# Comments for Planning Application 21/00006/FUL

Application Number: 21/00006/FUL

Address: 25 Chaloners Road York YO24 2TW

Proposal: Two storey side and single storey front and rear extensions following demolition of outbuilding

Drawing Title
 Existing & Proposed Site Plan & Block
 Plan

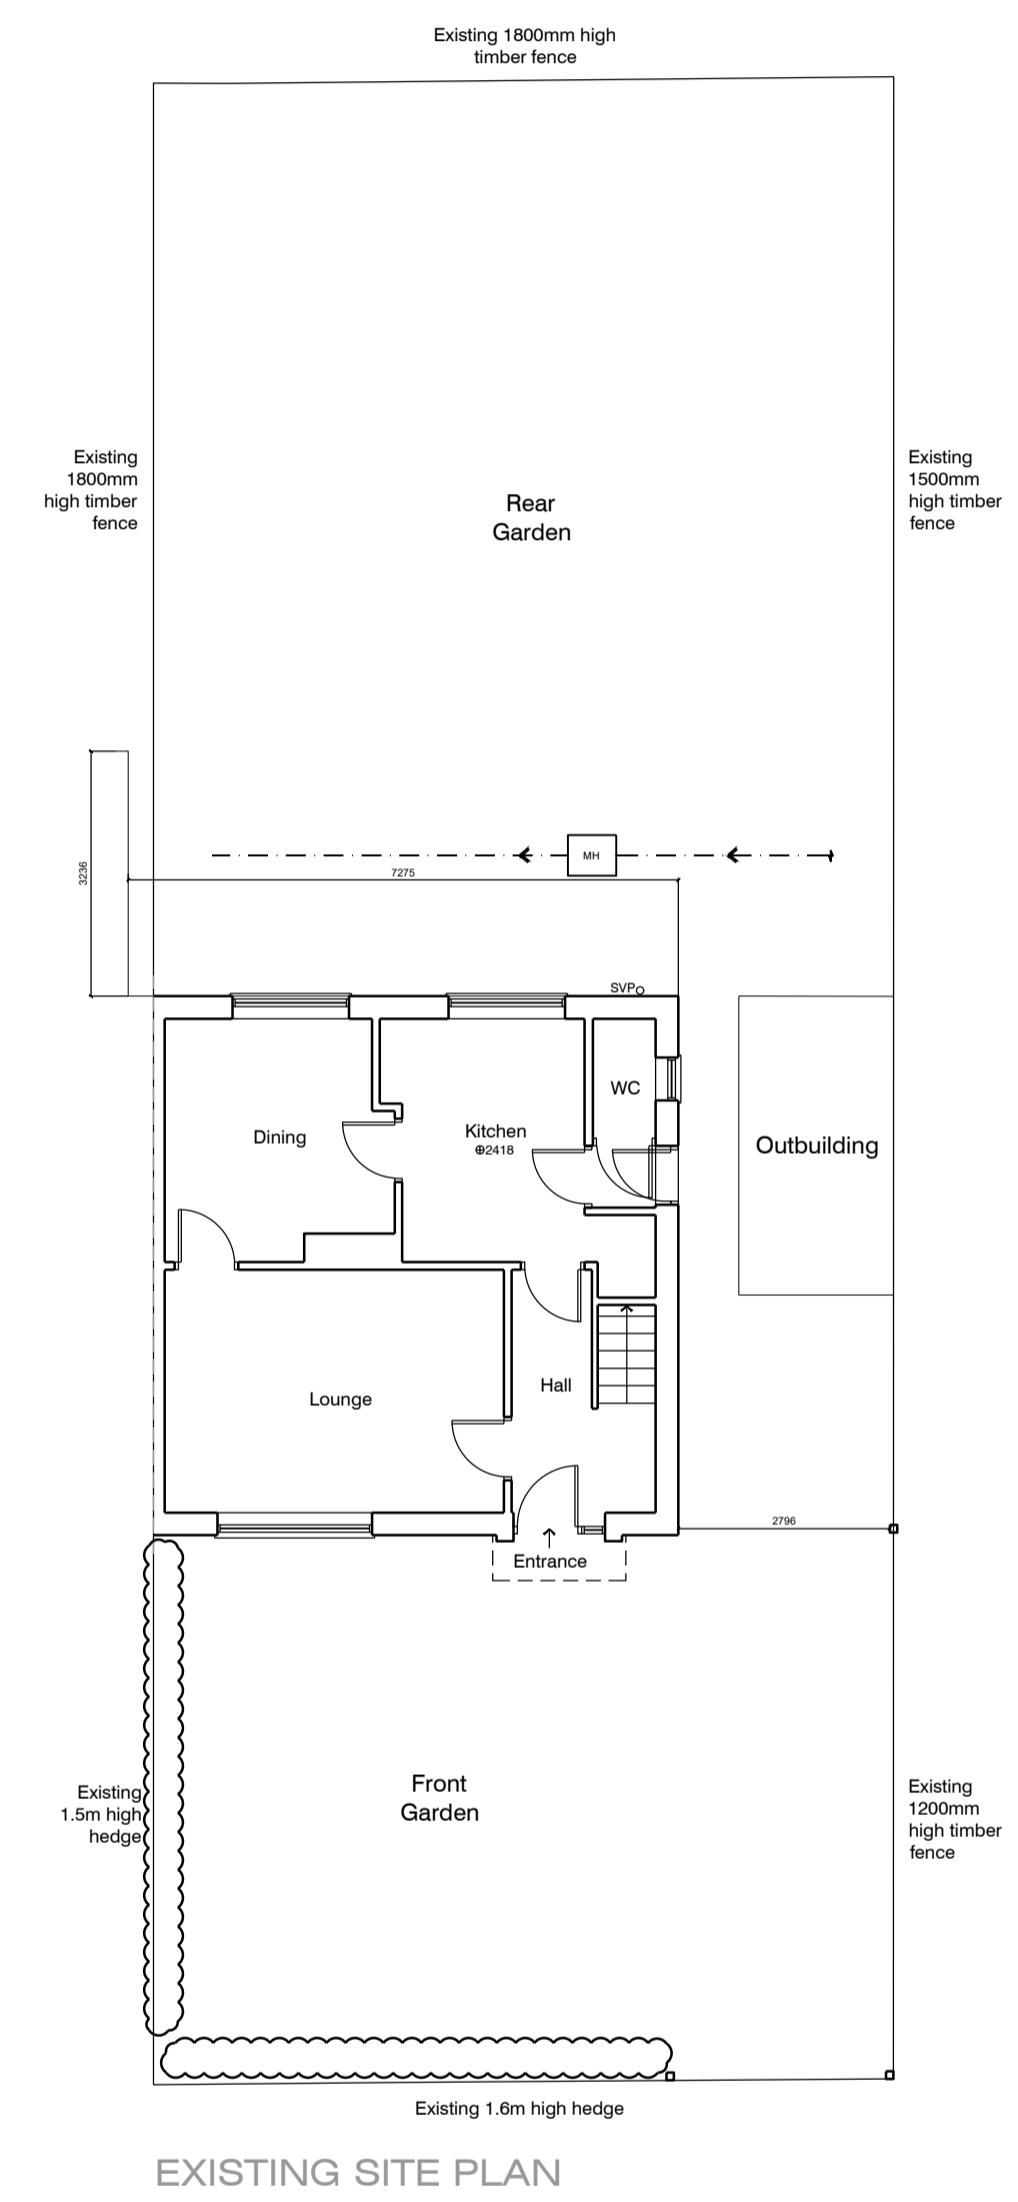
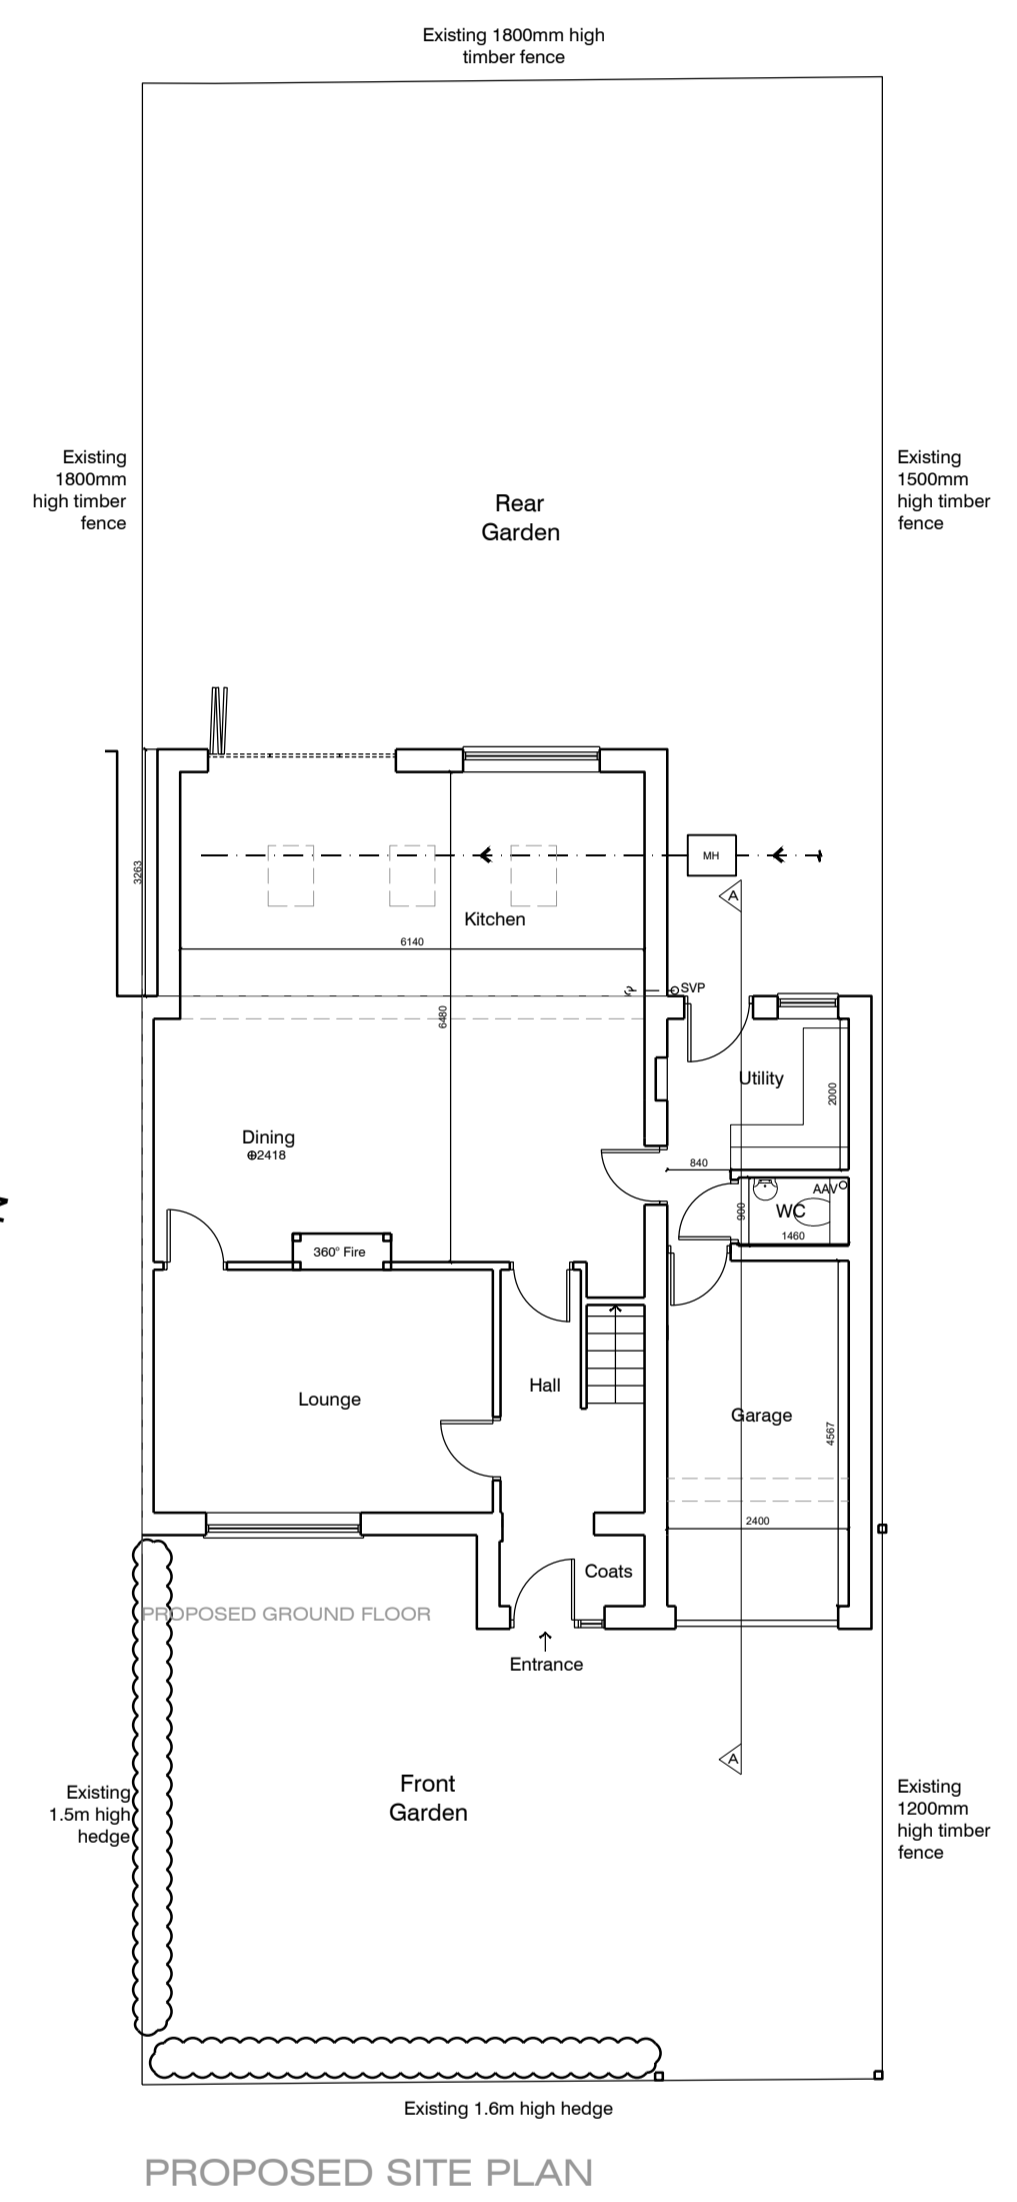
Comment: We note the plan to remove the outbuilding at 25 Chaloners Road in order to accommodate the planned development. The outbuilding is part of a single building which includes the outbuilding at 27 Chaloners Road. The party wall between the two adjoining outbuildings is on the boundary line and the roof is a single asbestos roof for both outbuildings. We would require details of how the proposed demolition of the outbuilding will affect our property.

In addition, we note the new development, whilst within the boundary for No.25 is close to the boundary line and therefore we require clarity of how the foundations for the new building will be installed i.e. will the foundations cross the boundary line into No.27?
